EPA Advice on Environmental Impact Statement – Noise Impacts

Thank you for the request for advice from Public Authority Consultation (PAE-9405812), requesting the review by the NSW Environment Protection Authority (**EPA**) of the Environmental Impact Statement (**EIS**) for the proposed Central Sydney Industrial Estate incorporating the Sustainable Road Resource Centre (SSD-10459) (**the Proposal**) at part Lot 100 DP 1168951 known as 9 Devon Street, Rosehill, NSW, 2142 (**the Premises**).

Request for advice on EIS

Central Sydney Industrial Estate incorporating the Sustainable Road Resource Centre

Drawing Title:
Riparian Corridor Section B-B
 DWG No: **SSD-09**

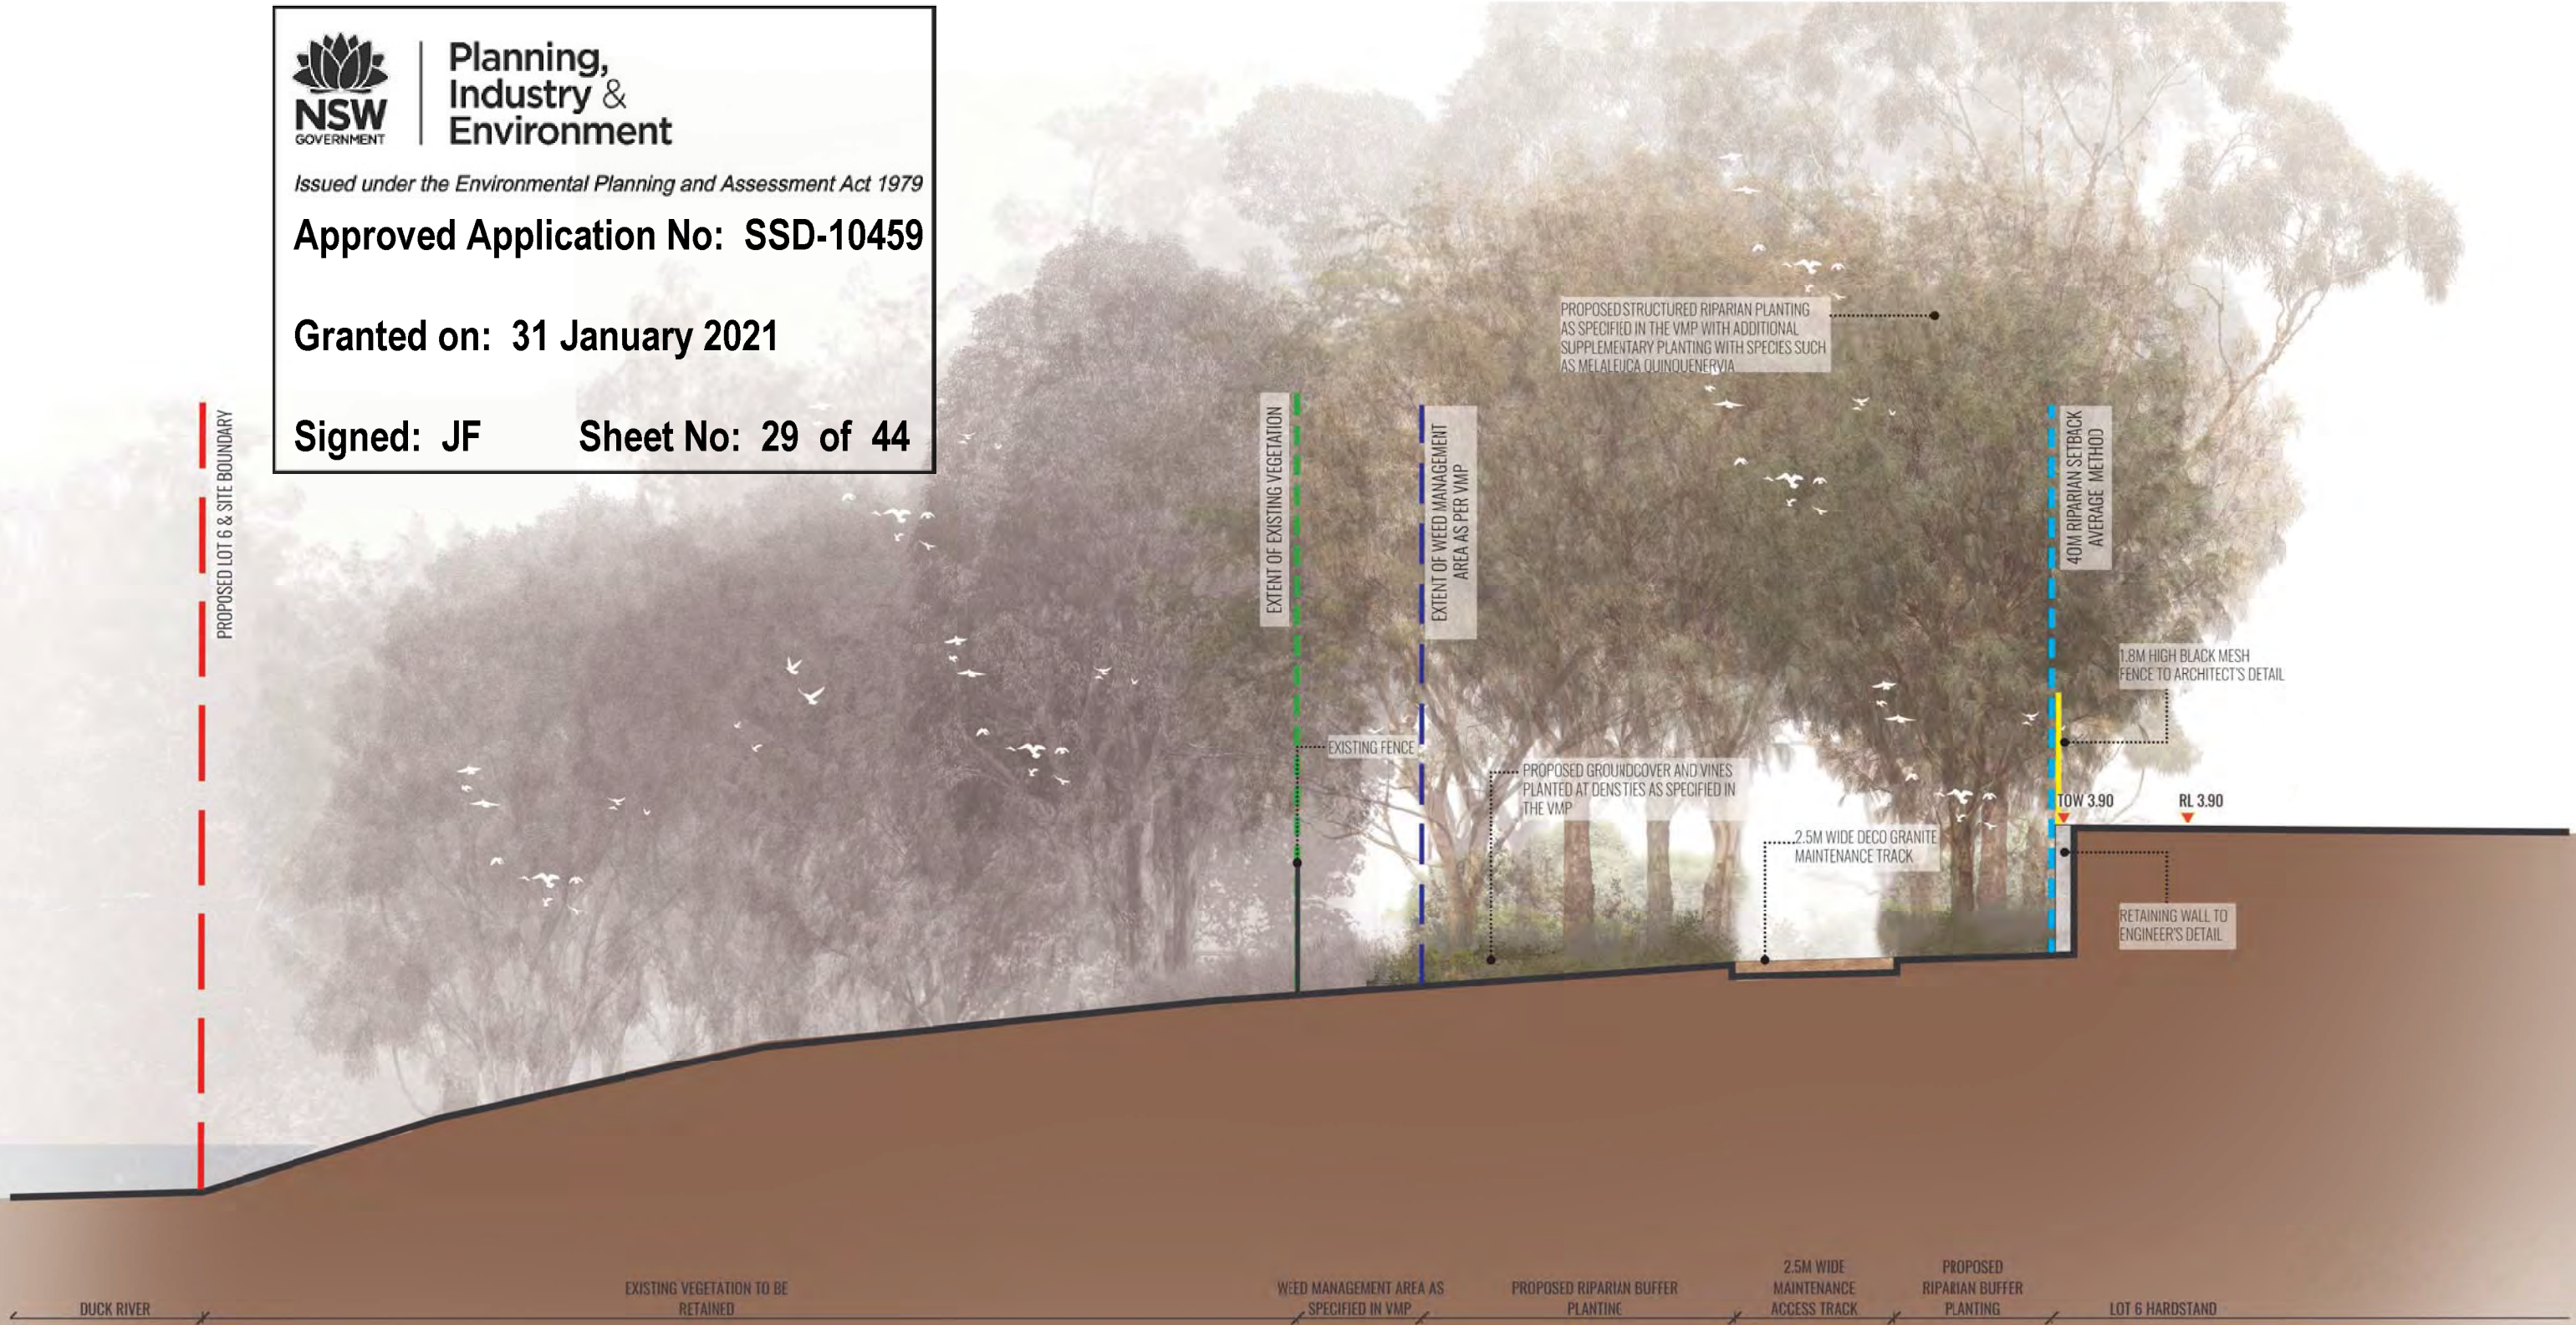
2. The VMP is not a comprehensive document and it is difficult to see how it will facilitate *'improvement'* in the riparian corridor. Further clarification is sought regarding the species planting list and ratios, concentration of plantings, maturity of plantings, and ground works or levelling required. The plantings should as closely as possible reflect the existing PCT. Weed removal should form part of the care for the whole riparian corridor and not stop halfway. The existing fence in the middle of the riparian corridor should be removed. Success criteria should include erosion and sediment control measures. Please clarify what is considered a *'suitably qualified and experienced'* person to compile annual reports. DPI Fisheries request that the annual VMP reports be sent to this office for consideration in addition to supplying them to the proponent.

3. A 2.5m road proposed through the riparian corridor negates the effectiveness of the corridor as an environmental mitigation. DPI Fisheries does not support the road through the riparian corridor. DPI Fisheries also seeks further information about the extent and purpose of the retaining wall adjacent to the riparian corridor. Generally, retaining walls have a negative effect on the environmental value of a riparian zone.
